EL PASO COUNTY STORMWATER MANAGEMENT PLAN CHECKLIST

EPC Project Number:

PPR-21-036

EROSION CONTROL PLAN - INTERIM
 DESIGN DEVELOPMENT

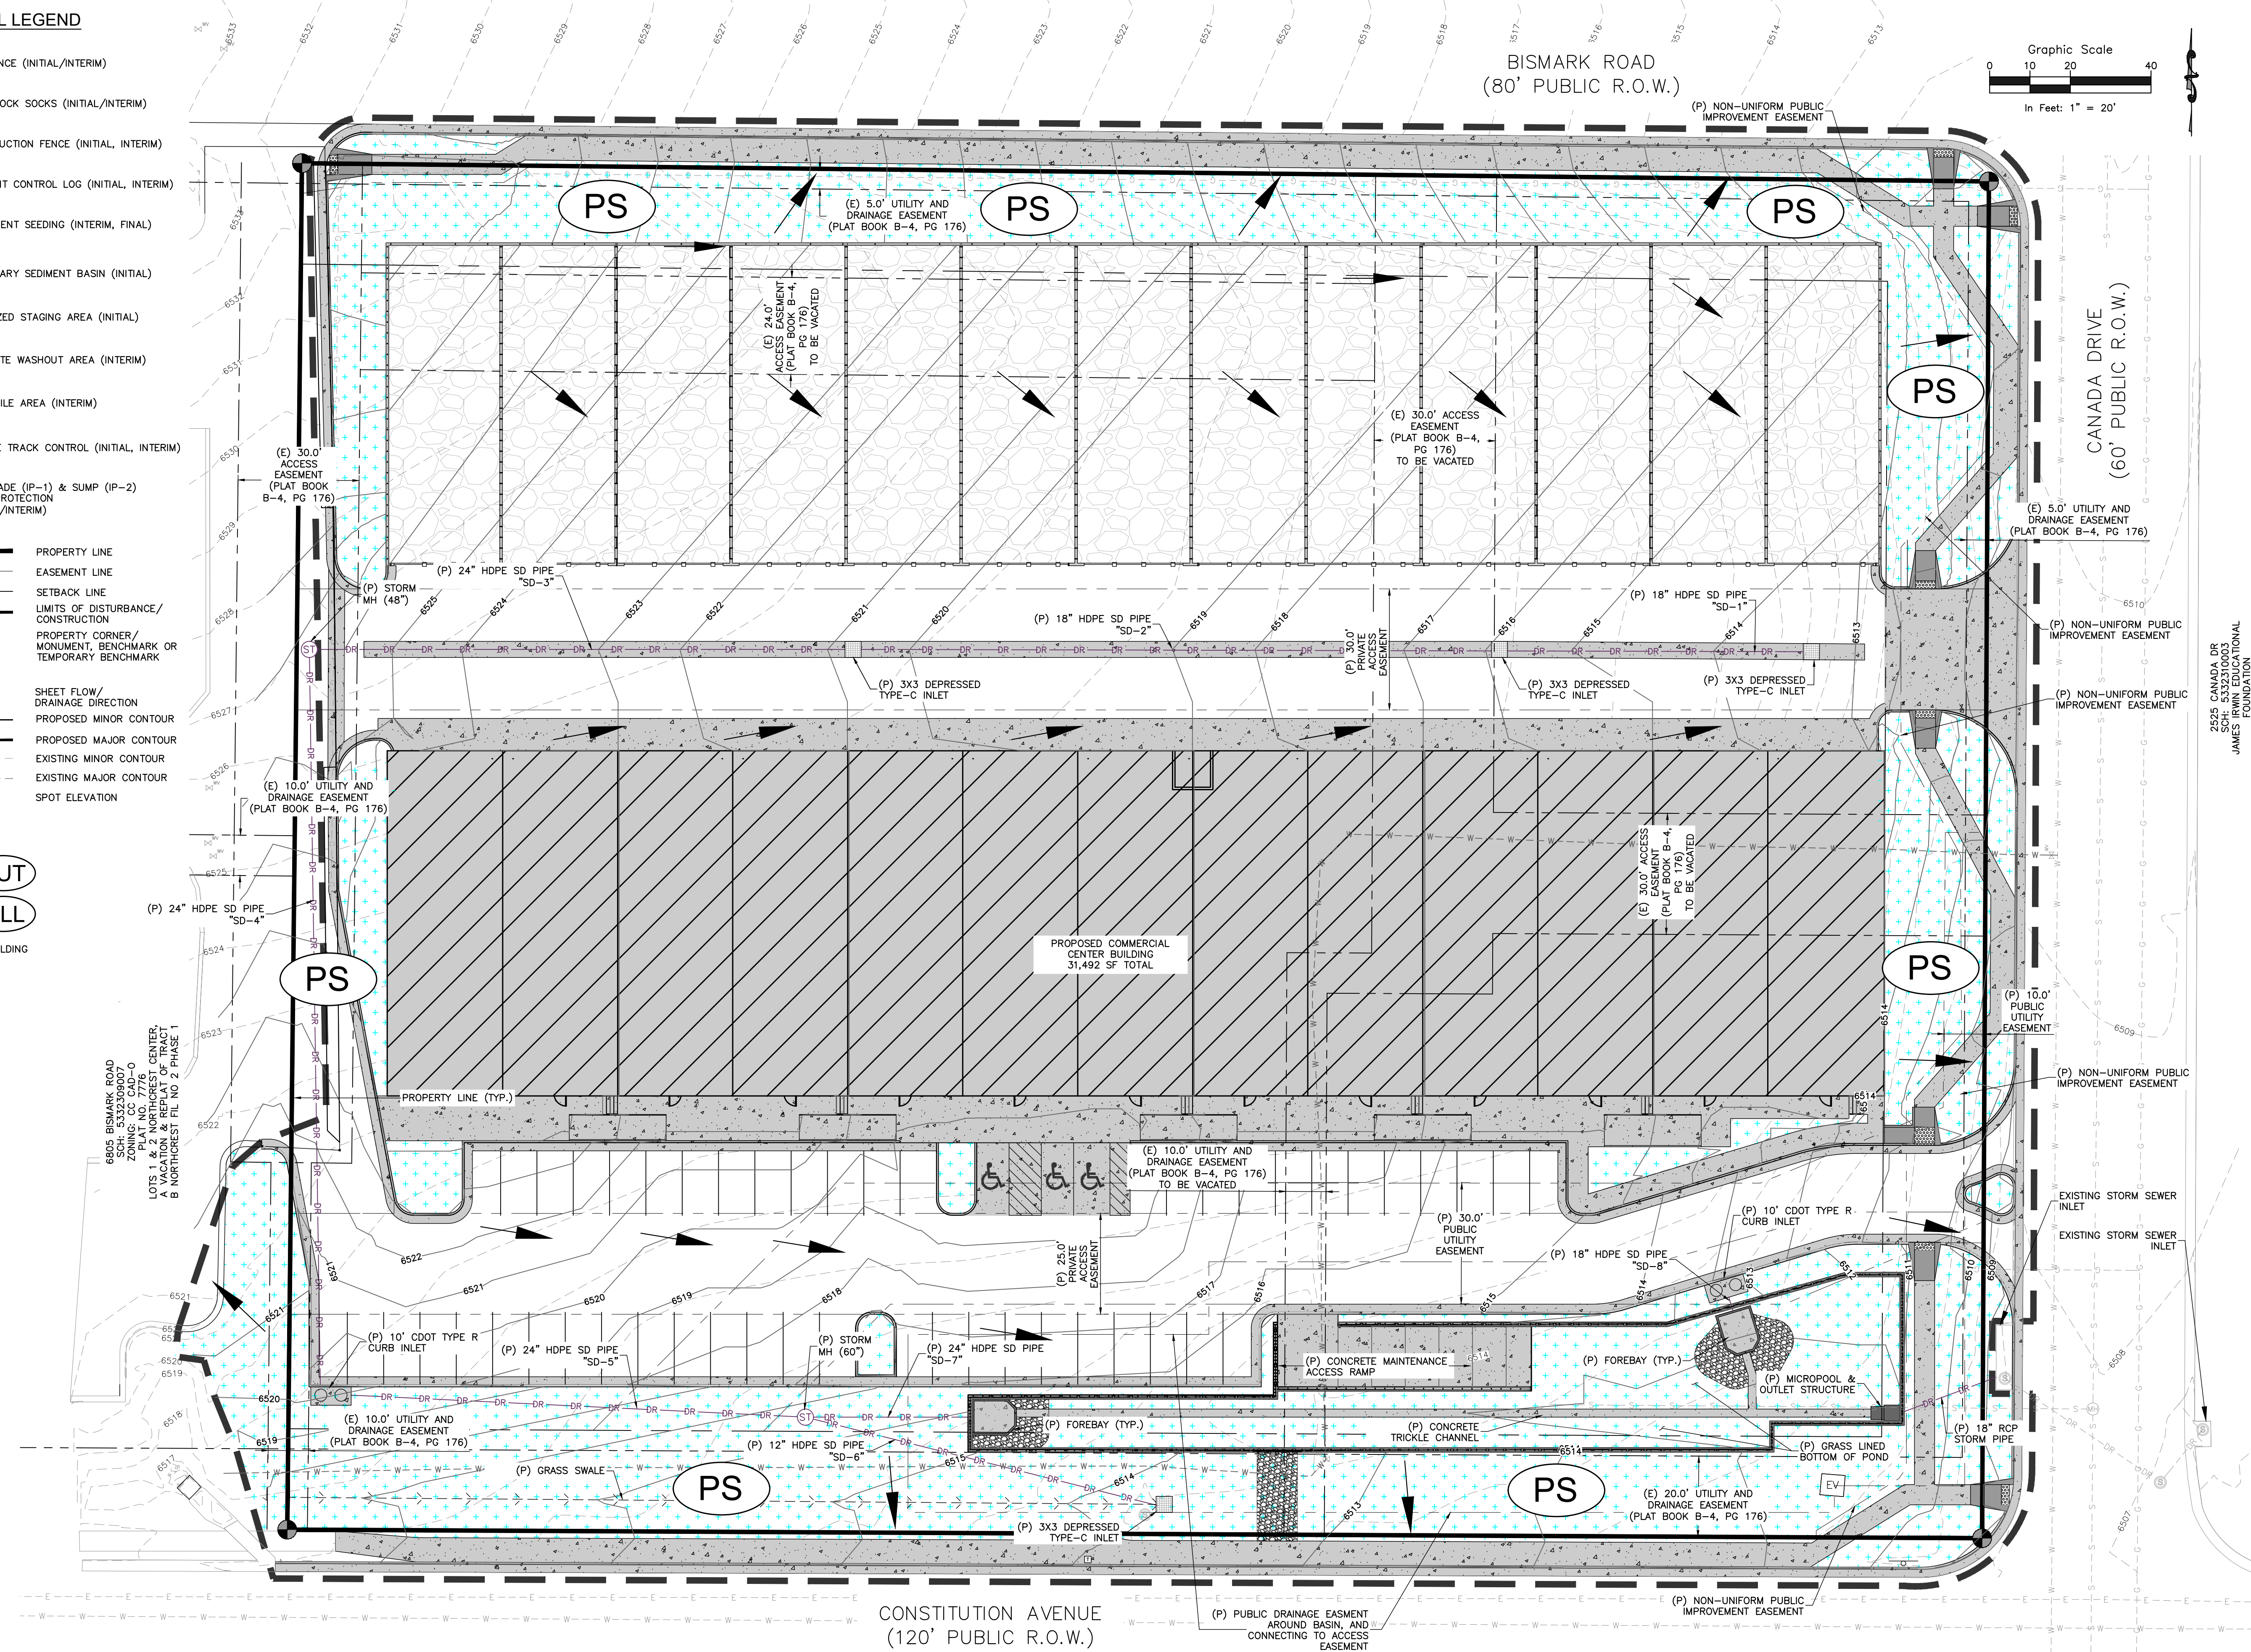
Applicant	EPC
17	SWMP Map to include: Reviewed GEC_v1		
17a	construction site boundaries		✓
17b	flow arrows to depict stormwater flow directions		✓
17c	all areas of disturbance		✓
17d	areas of cut and fill		X
17e	areas used for storage of building materials, soils (stockpiles) or wastes		X
17f	location of any dedicated asphalt / concrete batch plants		X
17g	location of all structural control measures		X
17h	location of all non-structural control measures		✓
17i	springs, streams, wetlands and other surface waters, including areas that require maintenance of pre-existing vegetation within 50 feet of a receiving water		✓
18	Narrative description of all structural control measures to be used. Modifications to EPC standard control measures must meet or exceed County-approved details		X
19	Description of all non-structural control measures to be used including seeding, mulching, protection of existing vegetation, site watering, sod placement, etc.		✓
